Ribble Valley Borough Council
By email

Your ref: 3/2023/0634
Our ref: DC/23/3022
Date: 11-SEP-23

Location: Primrose House Primrose Road Clitheroe BB7 1DR
Proposal: proposed single-storey self-build dwelling with associated car port

REQUEST FOR ADDITIONAL INFORMATION

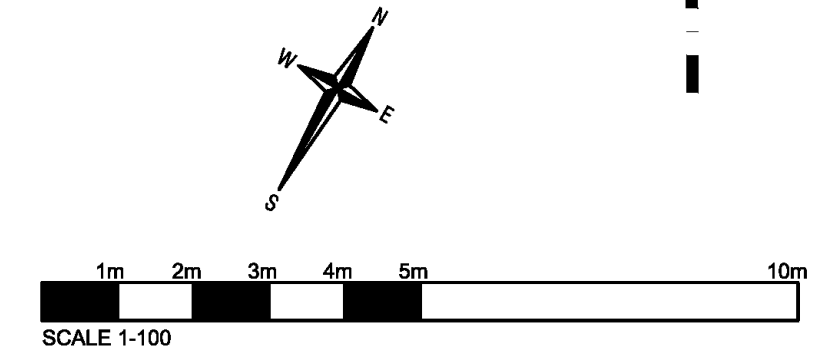
We request that the applicant submits a plan outlining the proposed levels (including finished floor levels and ground levels) shown in metres above Ordnance Datum and an indicative foul and surface water drainage strategy (including cover and invert levels). It is our recommendation this information is submitted for our review so that any risk of sewer surcharge can be further assessed. The applicant should note that it may be necessary to raise finished floor and ground levels and / or include mitigation measures to manage the risk of sewer surcharge.
